**PROJECT:**  
 RHETORIC SELF STORAGE  
 SITE DEVELOPMENT PLAN  
 - MINOR AMENDMENT  
 EL PASO COUNTY, COLORADO  
 JUNE 2026

PCD FILE: PPR2524

A100

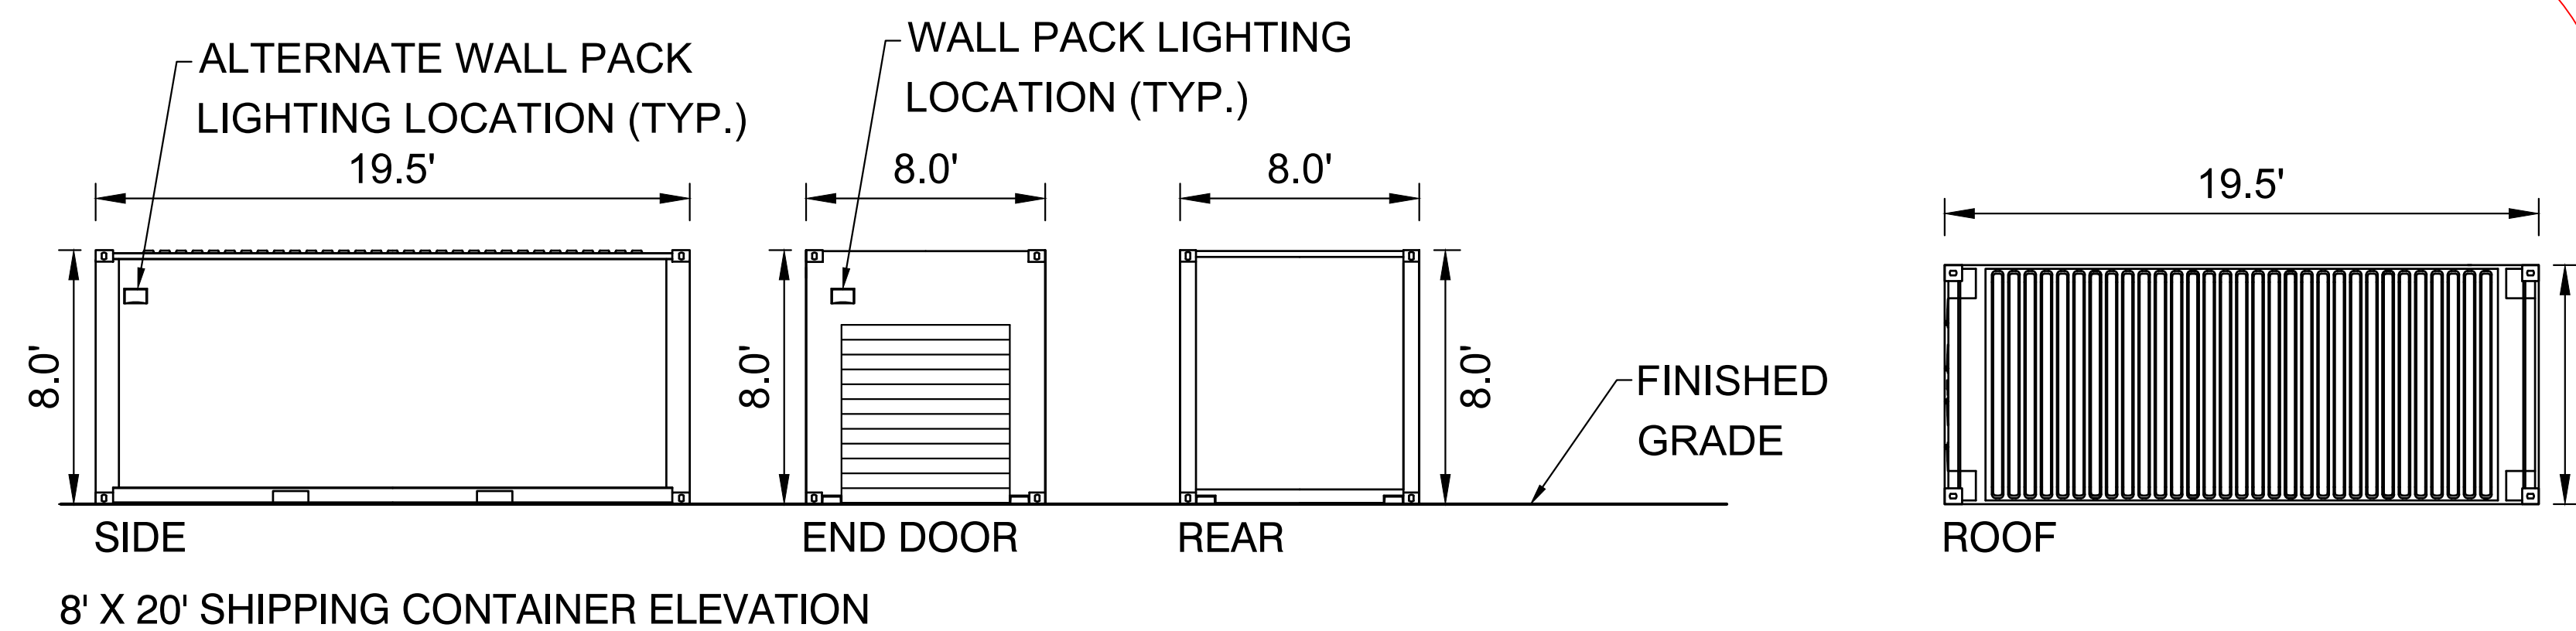
are there no smaller 8 x 10 units now?

are the 8 x 40 units also removed?

**Matrix response: Correct. The 8x10 and 8x40 units are not available and have been removed from the plan. All units are now the Boxwell 8'x20' (160 sq. ft.) self-storage units.**
